Table 2 – Response to Submissions Received on the Draft PPR

Note: The Responses to Submissions Received on the Draft PPR have ddressed the modified Project Application as they apply to the amended site area.

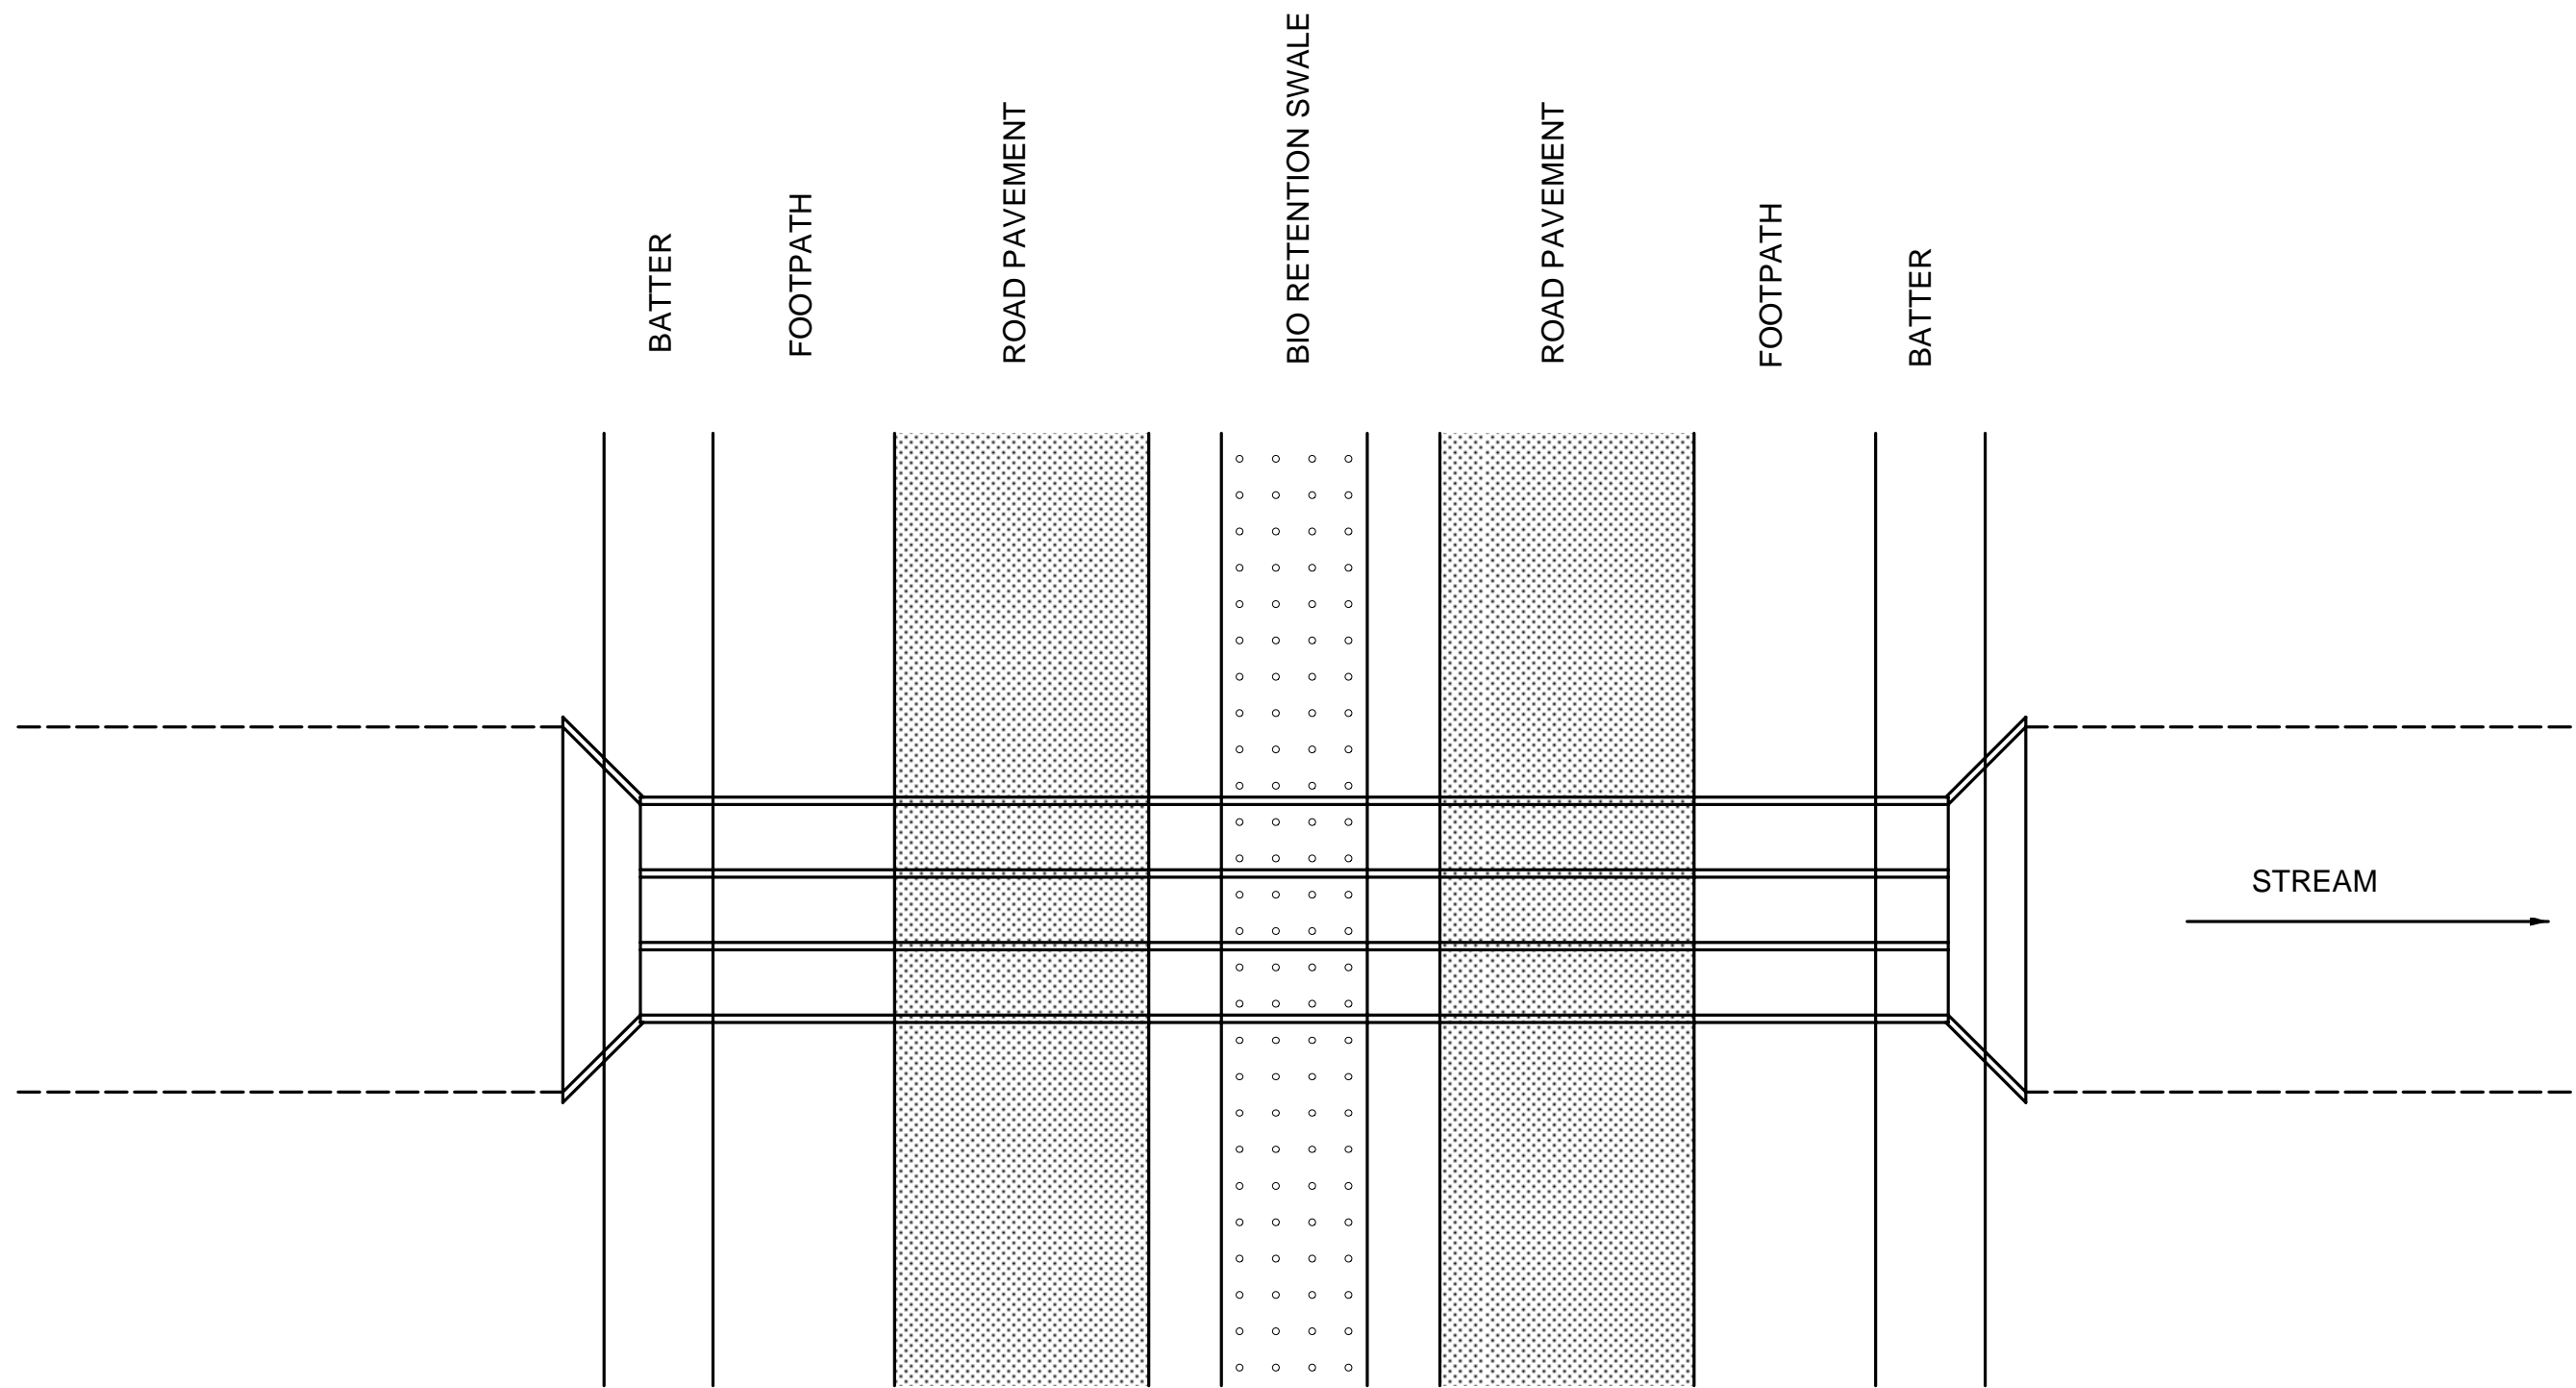
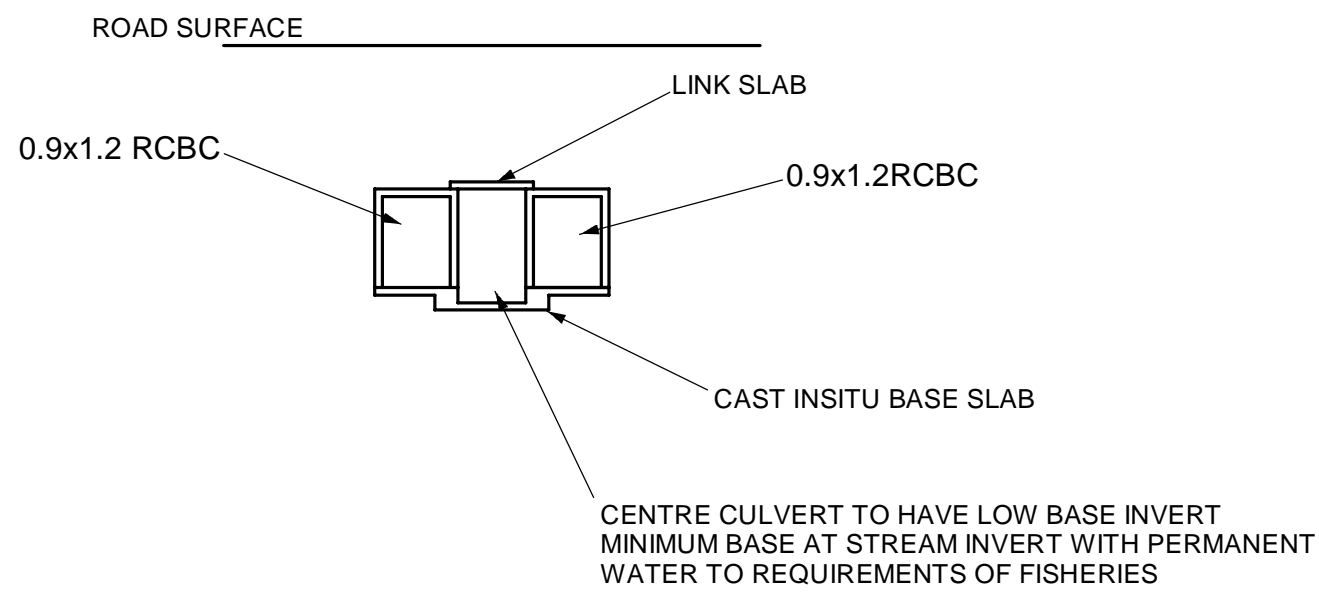
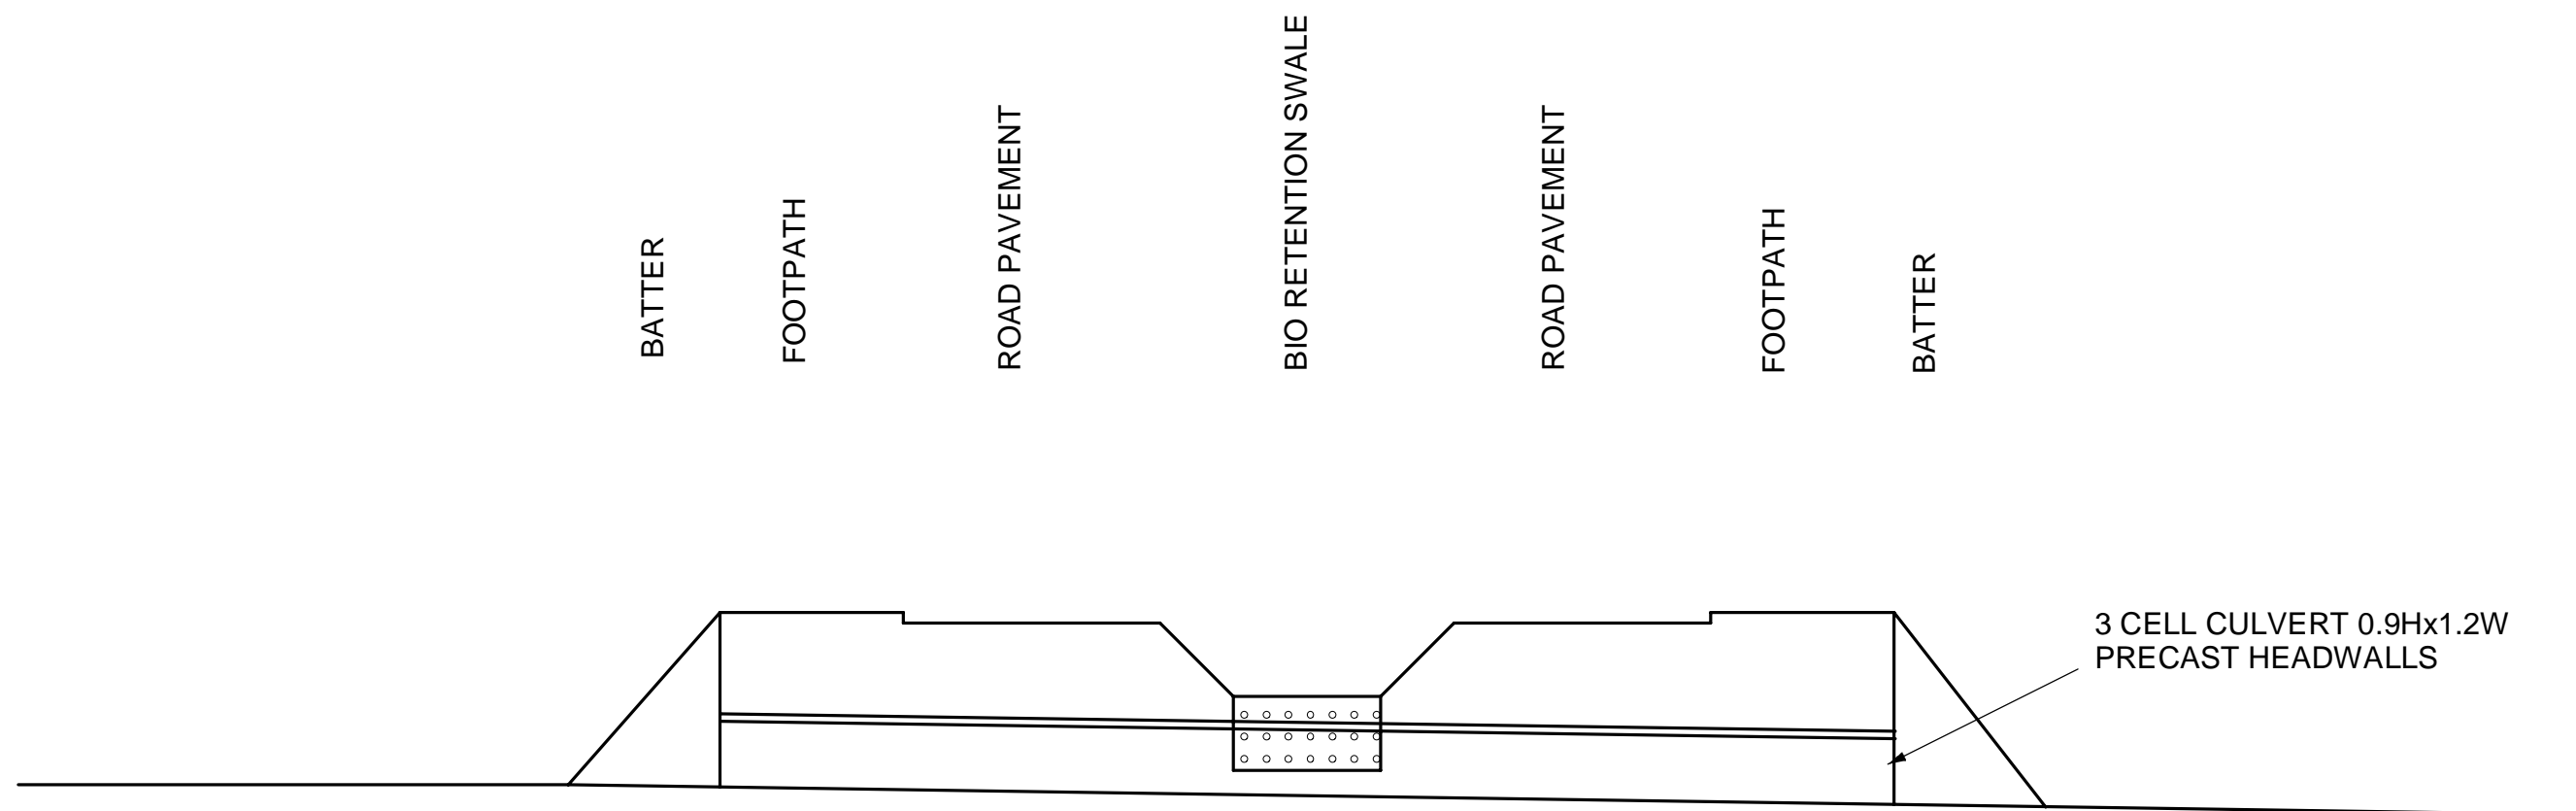
Department of	The VMP needs to provide for the APZs either side of the main connecting	Refer to response above in relation to the main connecting	No

Coffs Harbour City Council	The VMP does not take account of the Bushfire Report recommendation that a 19m APZ be established either side of the road creek crossing point. Has the Rural Fire Service (RFS) confirmed the requirement for this measure?	The VMP has been updated to include a 20 metre wide restricted planting zone to both sides of the main entry road which is consistent with the proposed 20 m wide Inner Protection Zones as proposed in Drawing No. 113 in Appendix 4 .	No
Coffs Harbour City Council	<p>The VMP planting densities are excessive, particularly for koala trees. Revegetation of 4.2 hectares is proposed to cost \$745000.00 under the Plan. More detail on species and numbers of each species is required. The plan does not differentiate between treatment of CRZ and vegetation buffer in terms of species and densities.</p> <p>The proponent should liaise with Councils Recreation Services Section on the VMP (please contact Ms S Stewart on telephone 6648 4875 or Ms C Brooke on telephone 6648 4871).</p>	Refer to response above in relation to proposed densities of the revegetation areas. The VMP has provided updated costings and provides further details in relation to species (Appendix 8).	No

Agency	Issue Raised	Response	Change to SOC?
Planning & Infrastructure	<p>road, where it crosses the riparian zone, as recommended in the bushfire report. Removal of any existing vegetation for provision of the APZ in this area may also impact the findings and conclusions of the James Warren ecological assessment in regard to the extent of EEC that is to be removed and/or retained, and this should also be reviewed.</p> <p>I note councils' comments on the PPR that further discussion is also required on the provision of an APZ to the main connecting road, particularly if it is intended that council take over long term maintenance. This could require council to maintain a revegetated riparian corridor in a bushfire hazard free state. Council's concerns need to be addressed.</p>	<p>road. The VMP proposes that the areas to either side of the main entry road will be maintained as "restricted planting zone". The restricted planting zone will largely be revegetated in accordance with the composition of the Freshwater wetland EEC. This community is naturally occurring in the Riparian Corridor on the site and typically has a limited number or no woody species (DECC 2008). There will be no removal of vegetation from the restricted planting area. Refer to Appendix 8.</p>

Rev	Date	Revision	Check
B	APRIL 13	SW AREA CHANGED TO LOW PRESSURE SYSTEM	
A	JULY 12	PREFERRED PROJECT DETAIL

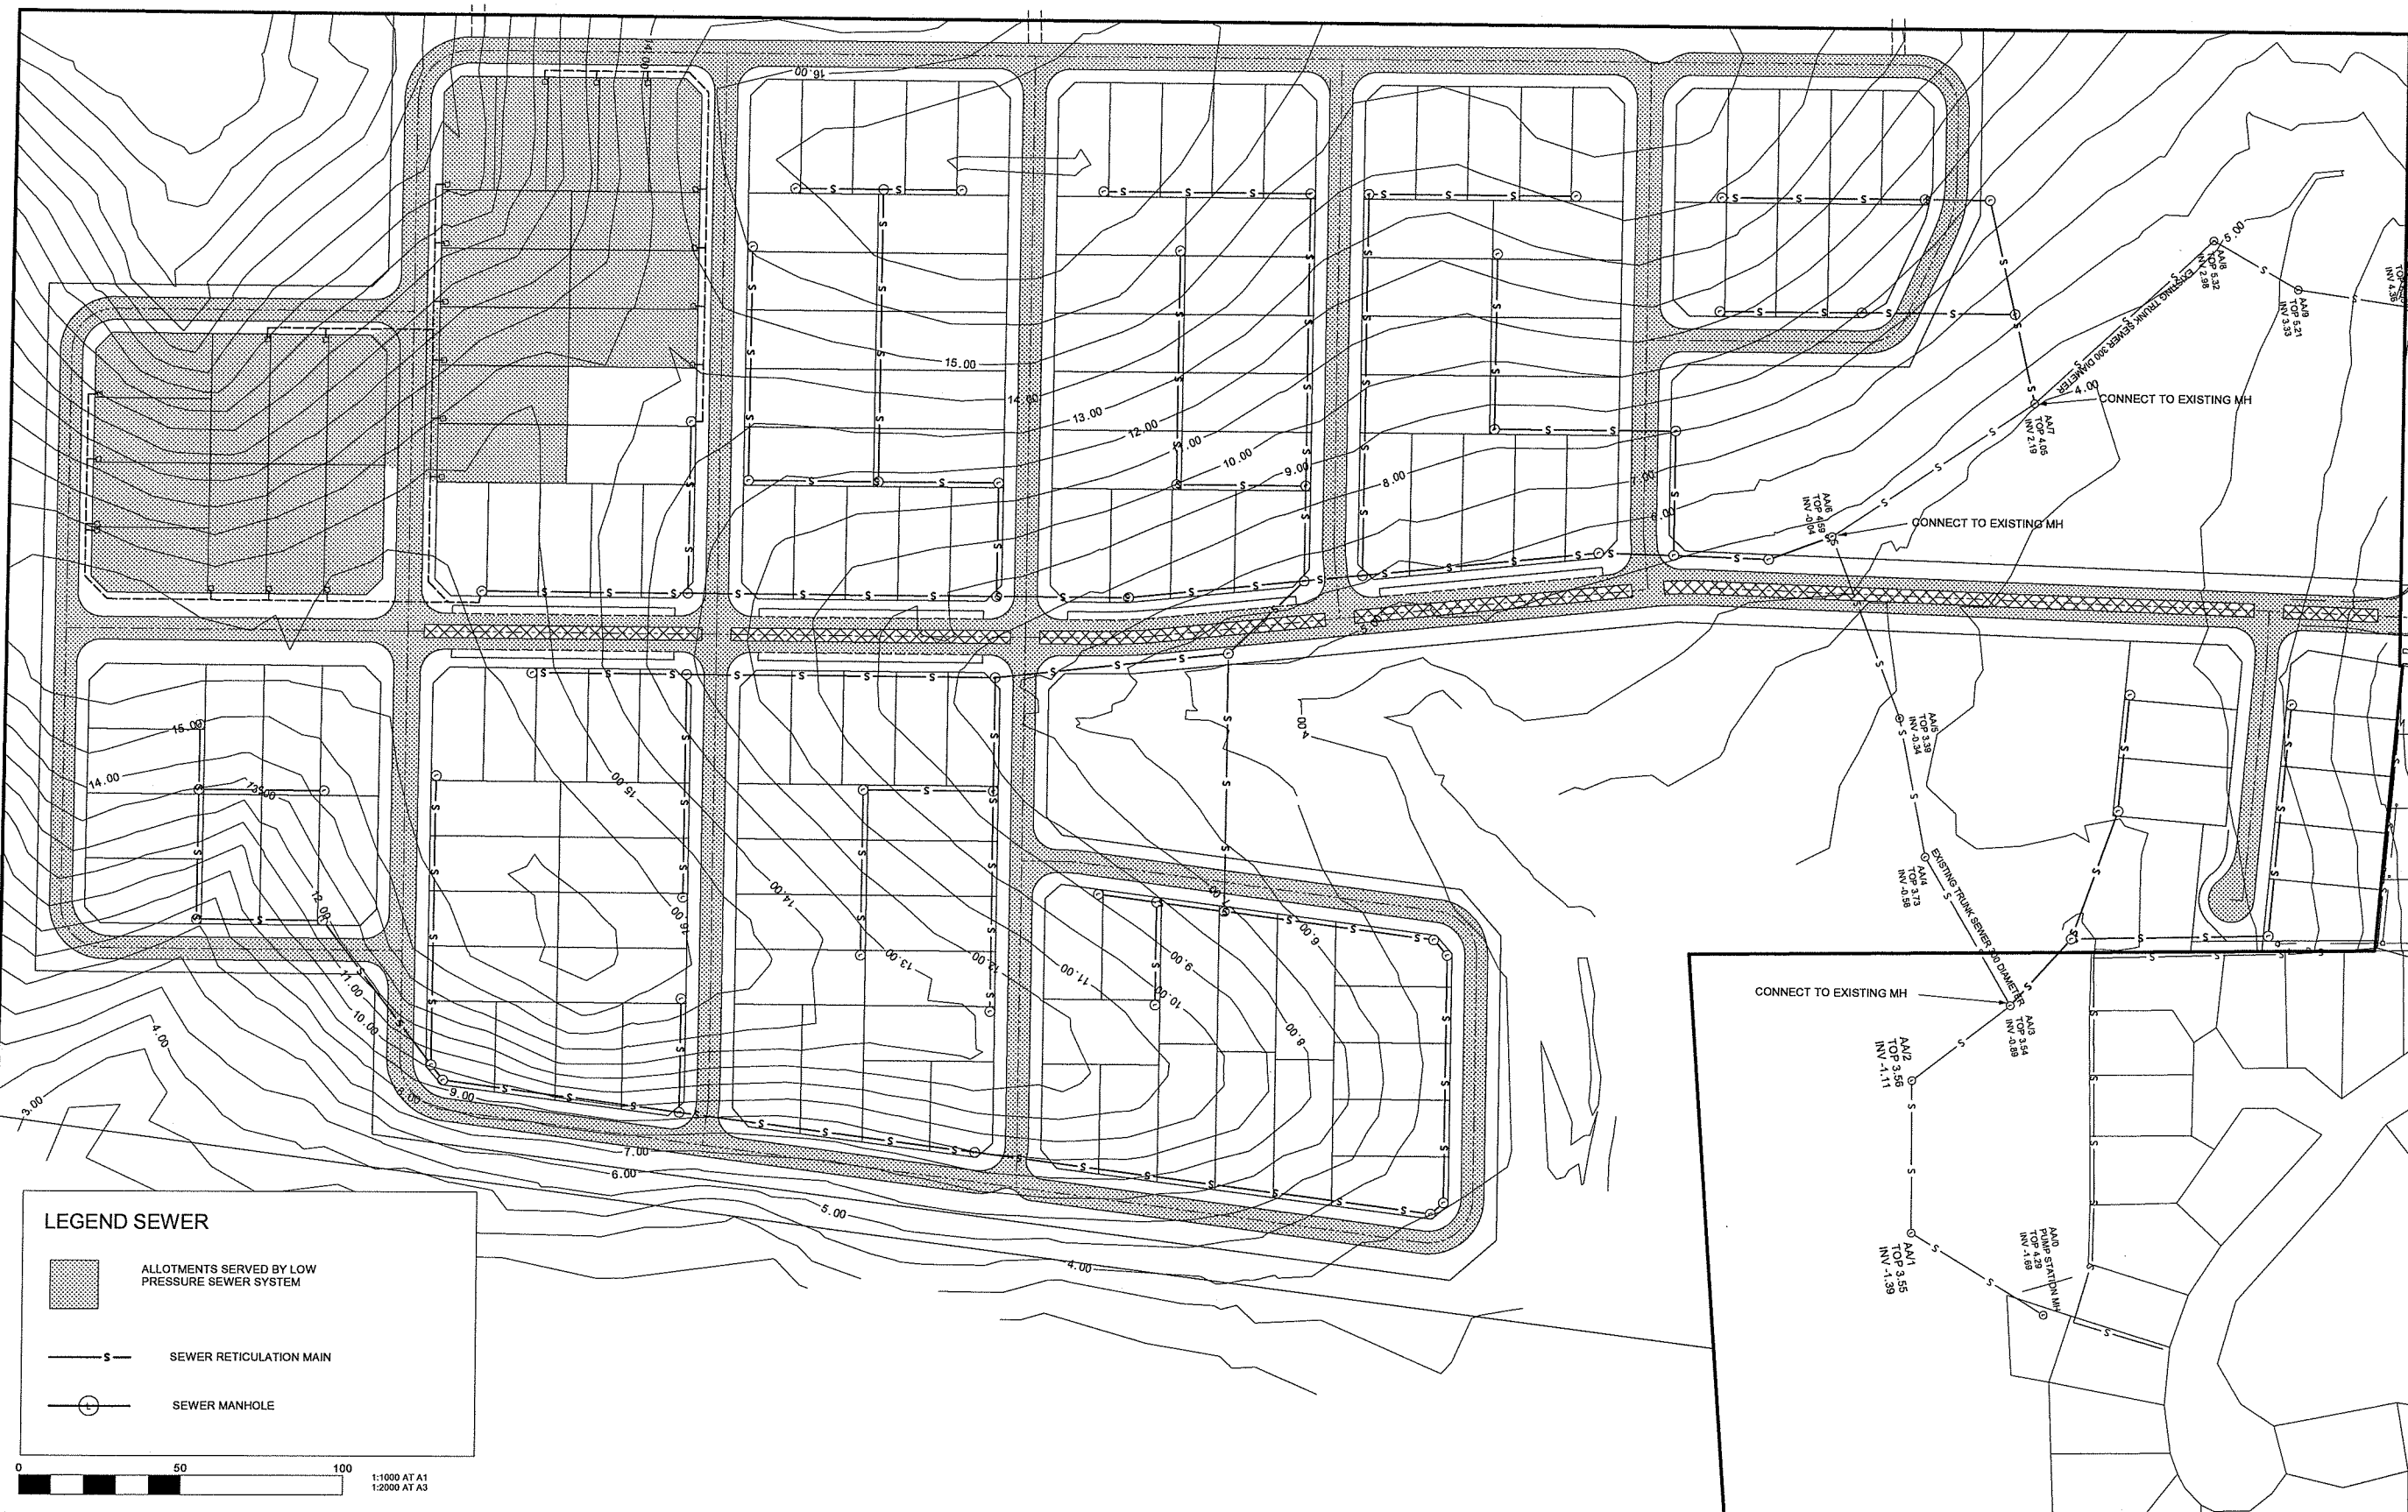
Agency	Issue Raised	Response	Change to SOC?
Coffs Harbour City Council	A sewer pumping station (SPS) is proposed to serve 23 lots in the south western corner of the site. A SPS servicing this few properties is not economically viable to Council. A Low Pressure System, conforming to Council's Policy, could be employed in this area. The consent could be conditioned accordingly.	A low pressure sewer system has now been incorporated into the subdivision design for the 23 lots in the south western corner of the site. Refer to Drawing No 111 in Appendix 4 .	No
Department of Primary Industries	The proponent has altered the development layout consistent with the recommendations detailed in the Office of Water's submission dated 14 March 2011 to the Environmental Assessment. In particular the relocation of the stormwater infrastructure out of the riparian zone is acknowledged.	Noted. No response required.	No
